September 9, 2025

RE: Take 5 Oil Change
2030 Gibson Blvd. SE
Traffic Circulation Layout
Engineer's Stamp 08-28-23 (M15-D021E)

Please find below our responses addressing the City of Albuquerque TCL 2nd Submittal Review comments for the proposed project located at 2030 Gibson Blvd. SE.

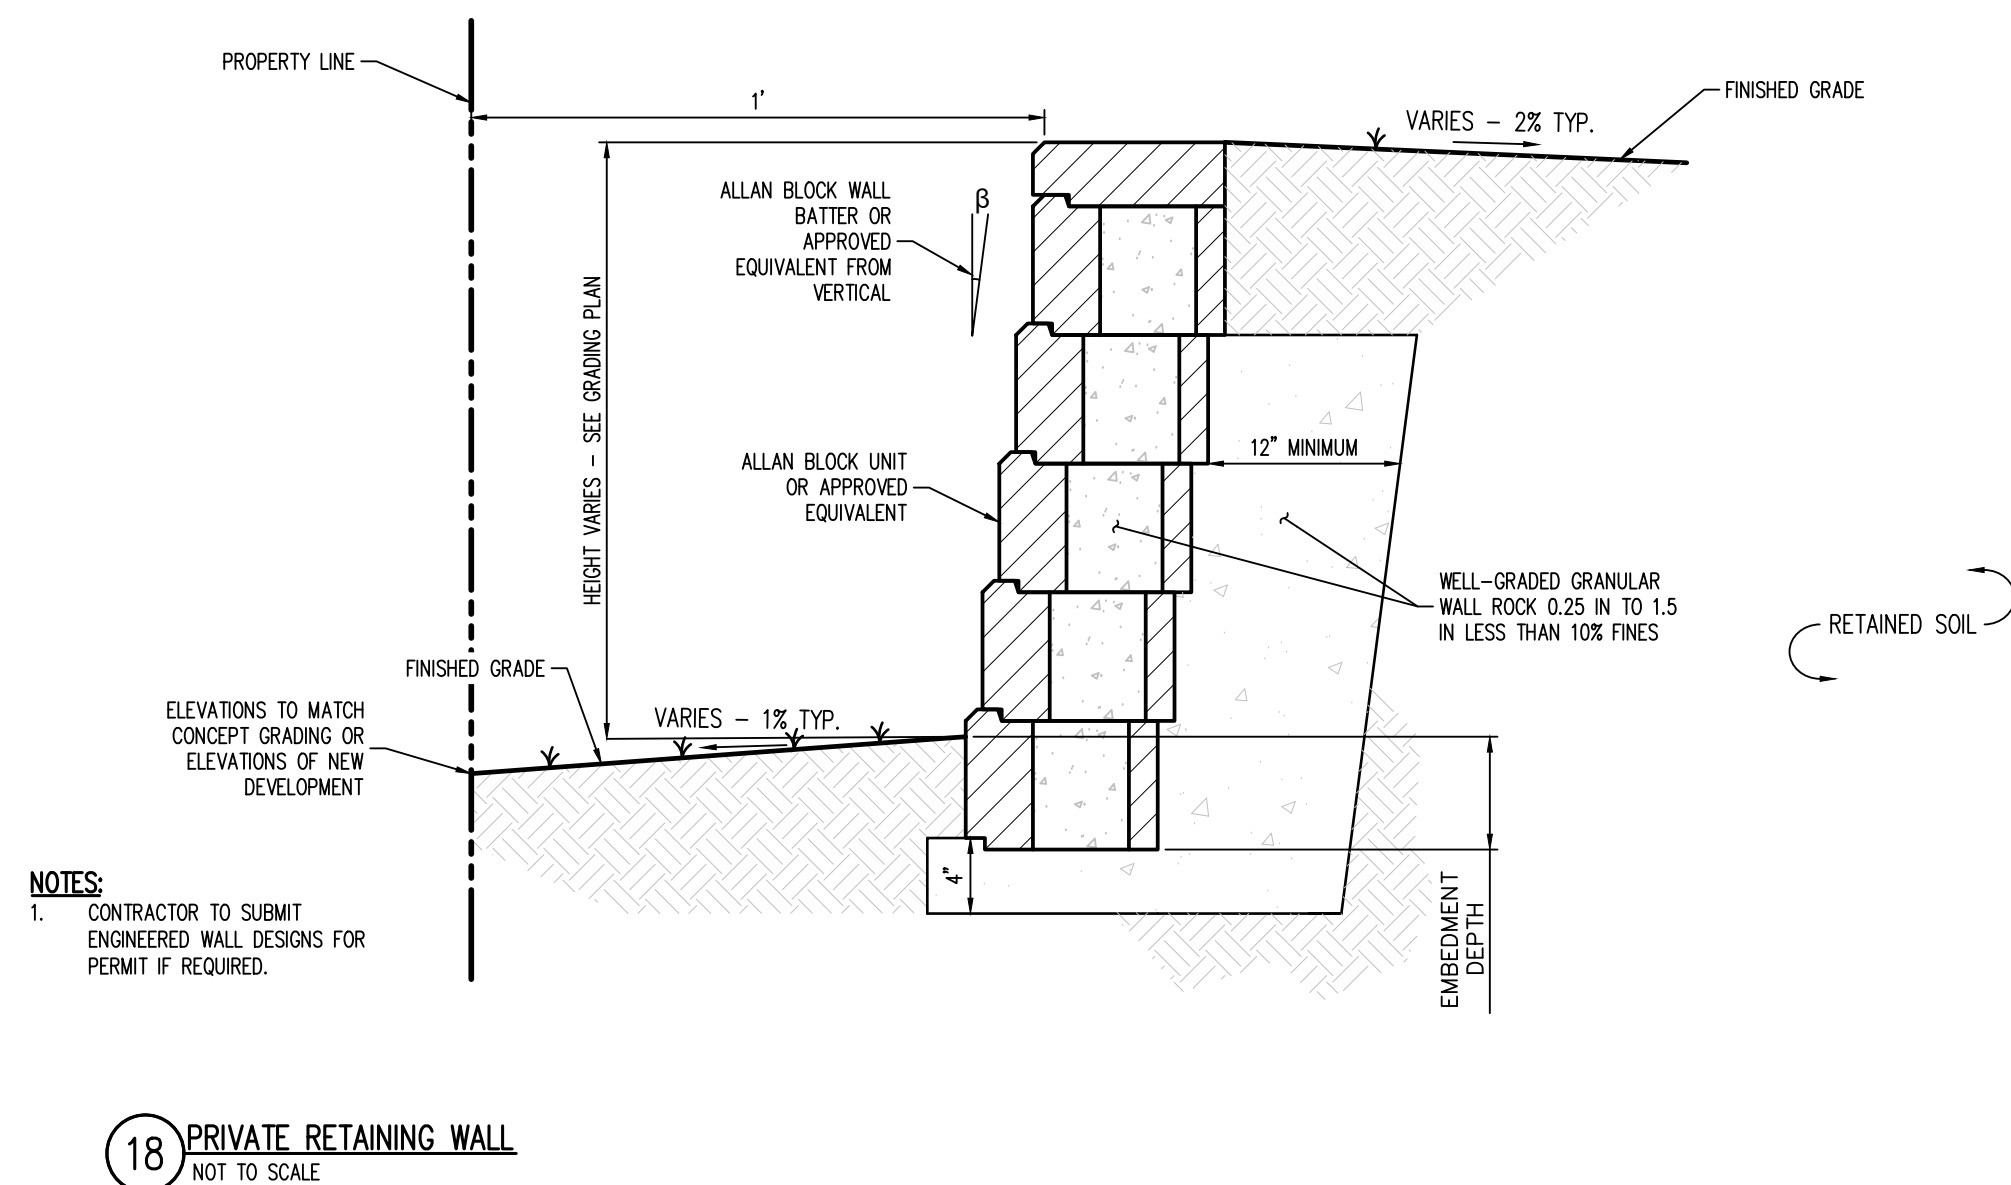
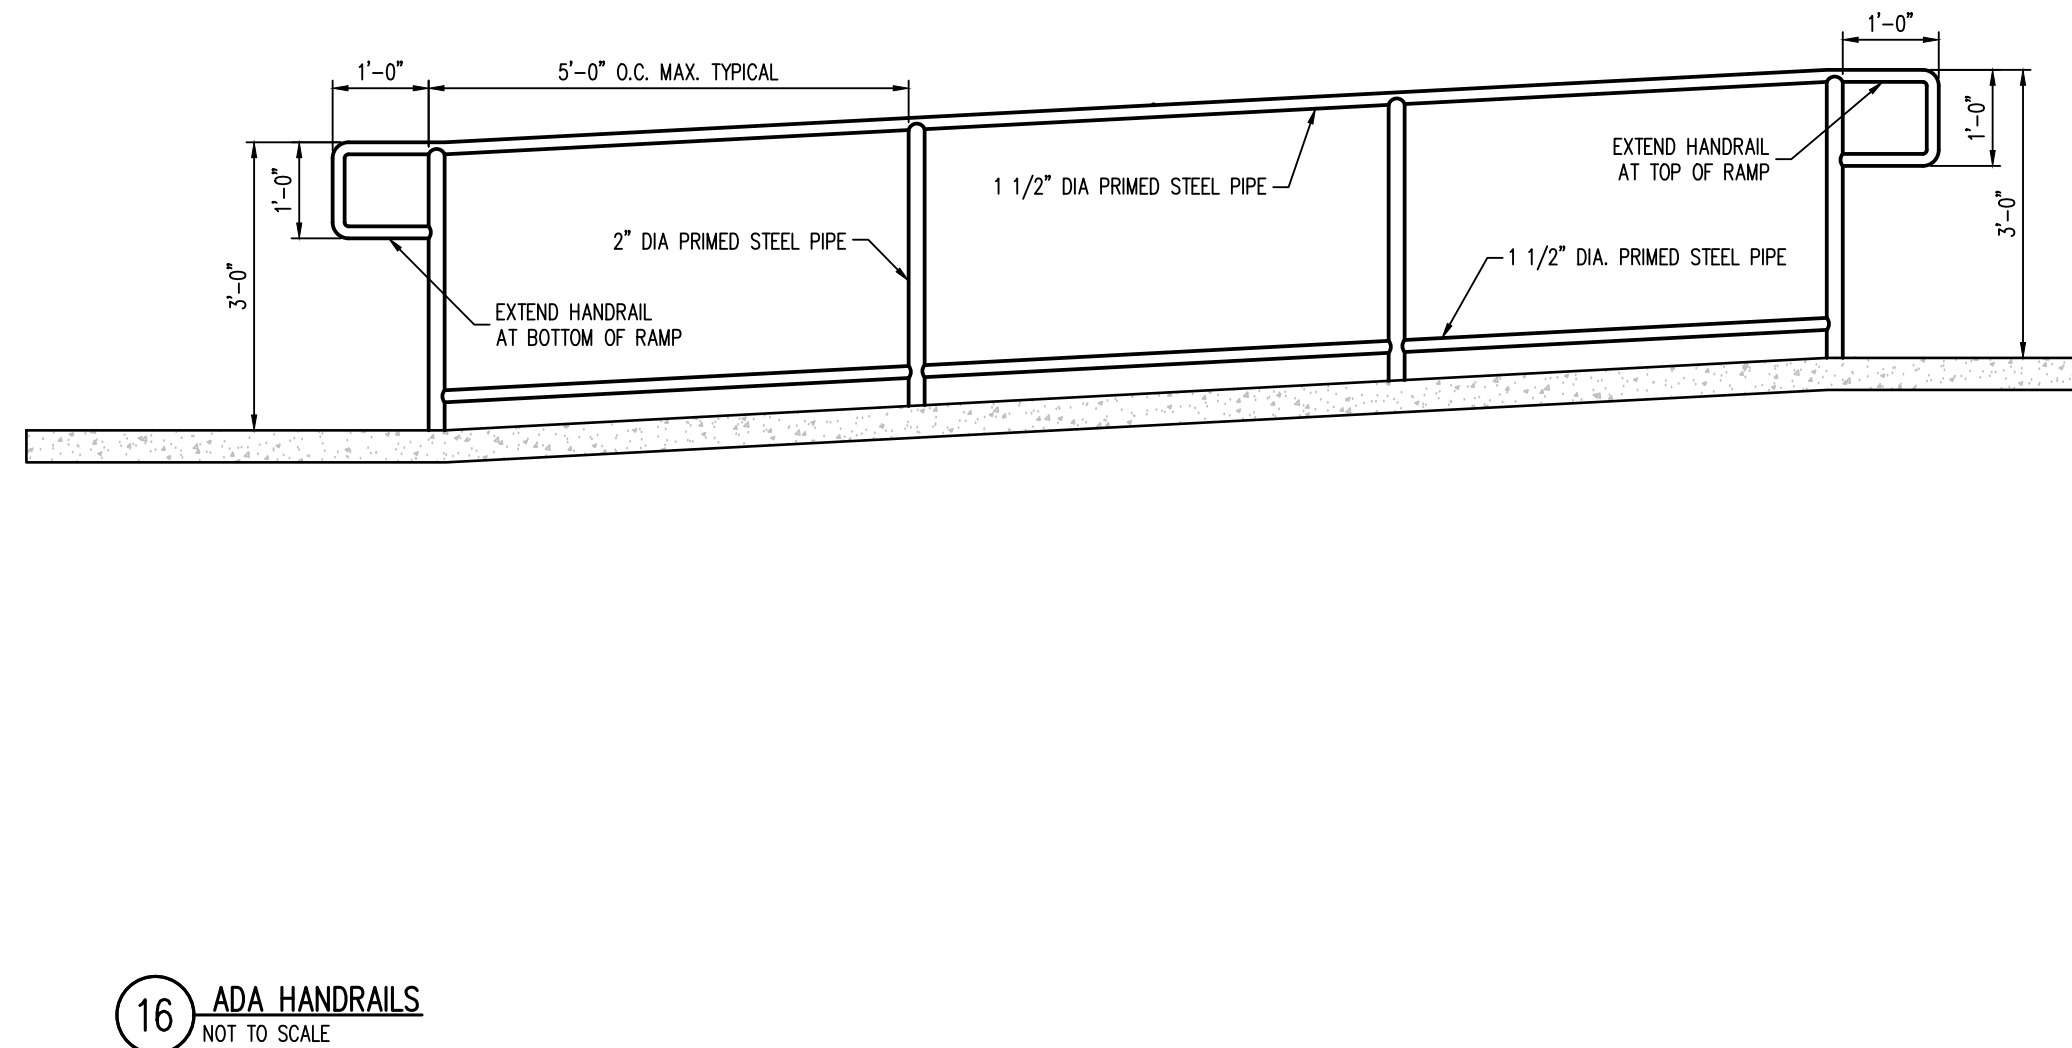
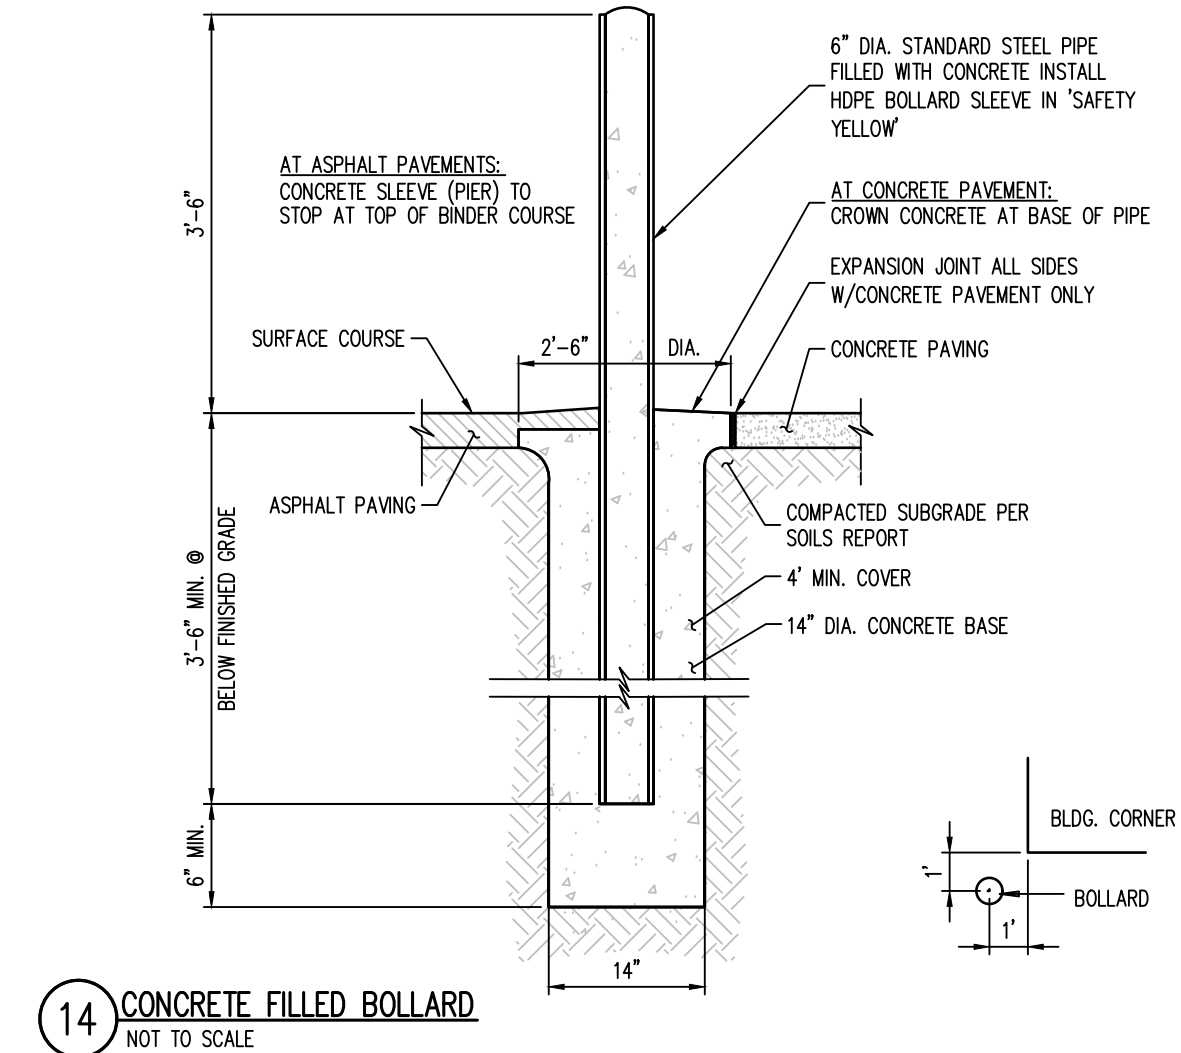
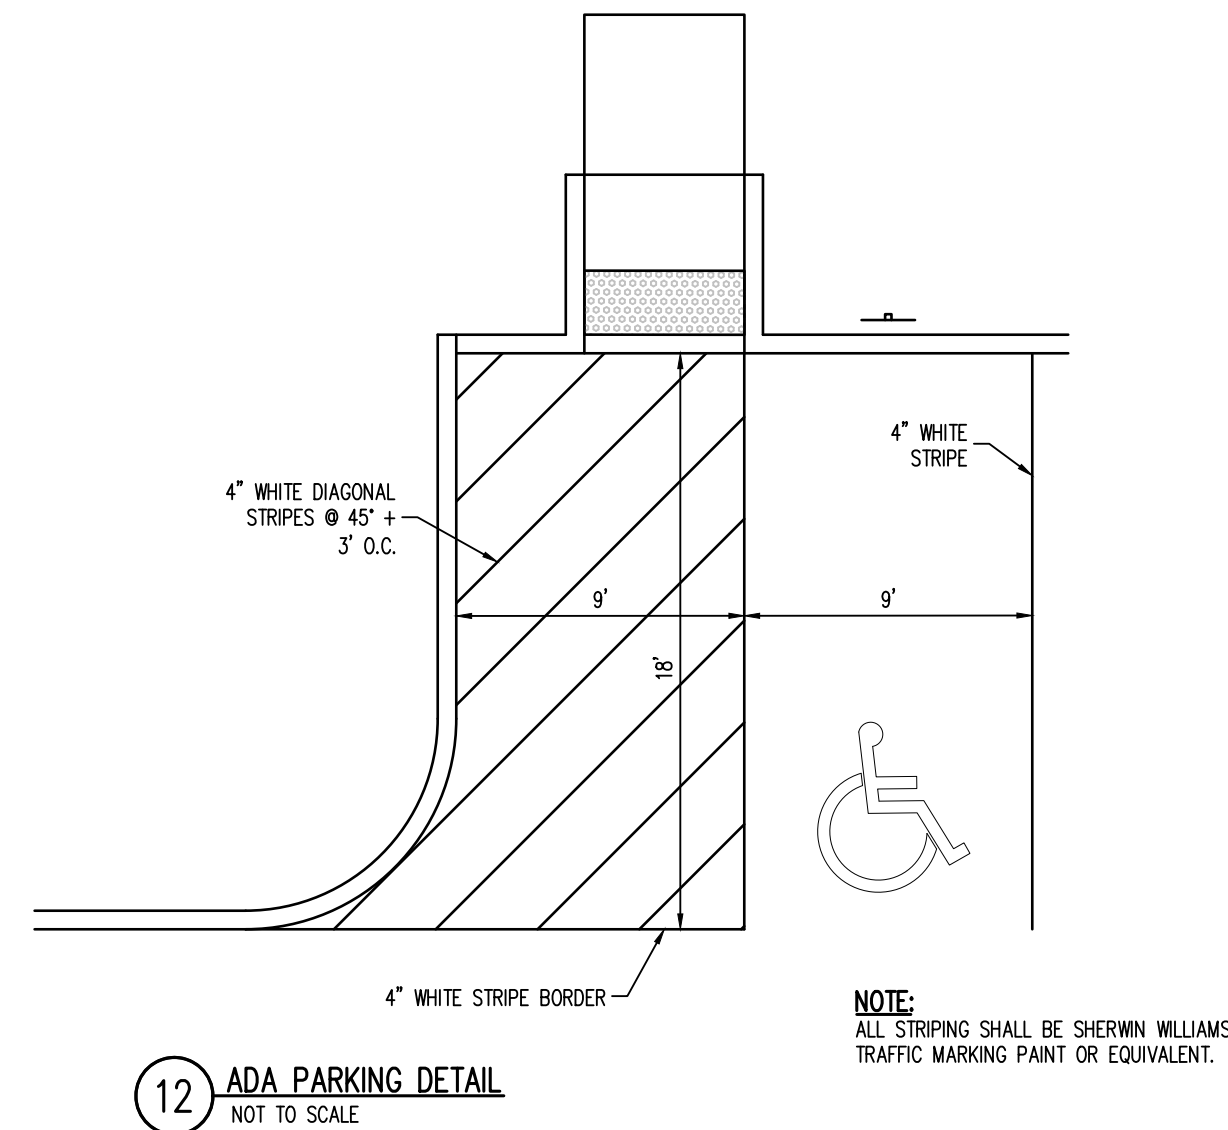
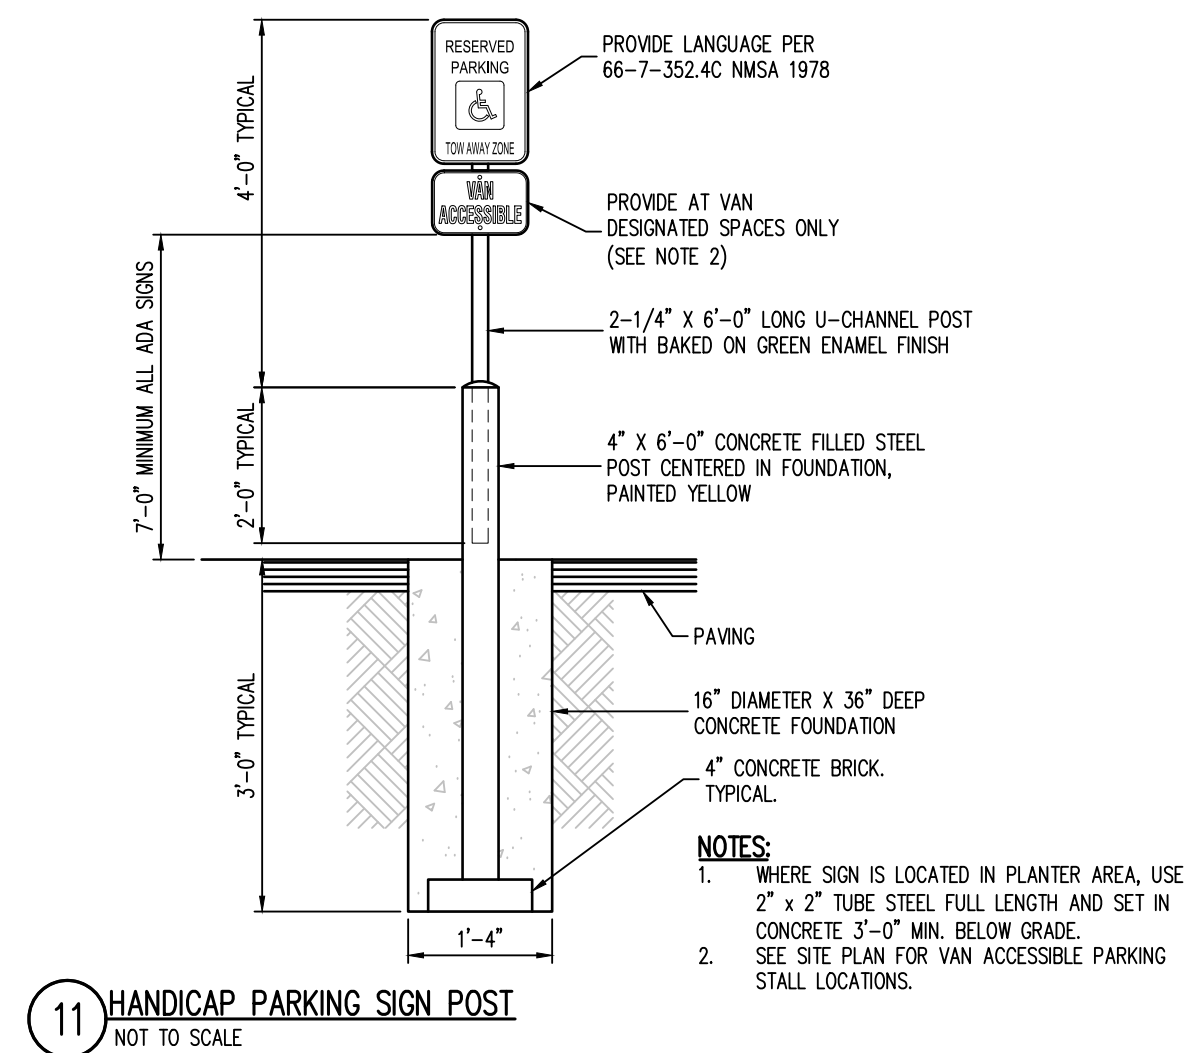
1. Detail Sheet C1.4

- a. The ADA accessible parking sign must have the required language per 66-7-352.4C NMSA 1978 "Violators Are Subject to a Fine and/or Towing." Please call out detail and location of signs.

- b. The private retaining wall details must be removed.

3. The "STOP" sign must comply with MUTCD requirements (provide details).

Response: ADA accessible parking sign detail revised to include above language. Sign location identified on Site Plan Sheet C1.0, Schedule Note 17.

Response: Private retaining wall detail is associated with retaining wall along the west side of the one-way drive aisle and is related to transportation.

Response: "STOP" sign detail to comply with MUTCD requirements added to Sheet C1.4.
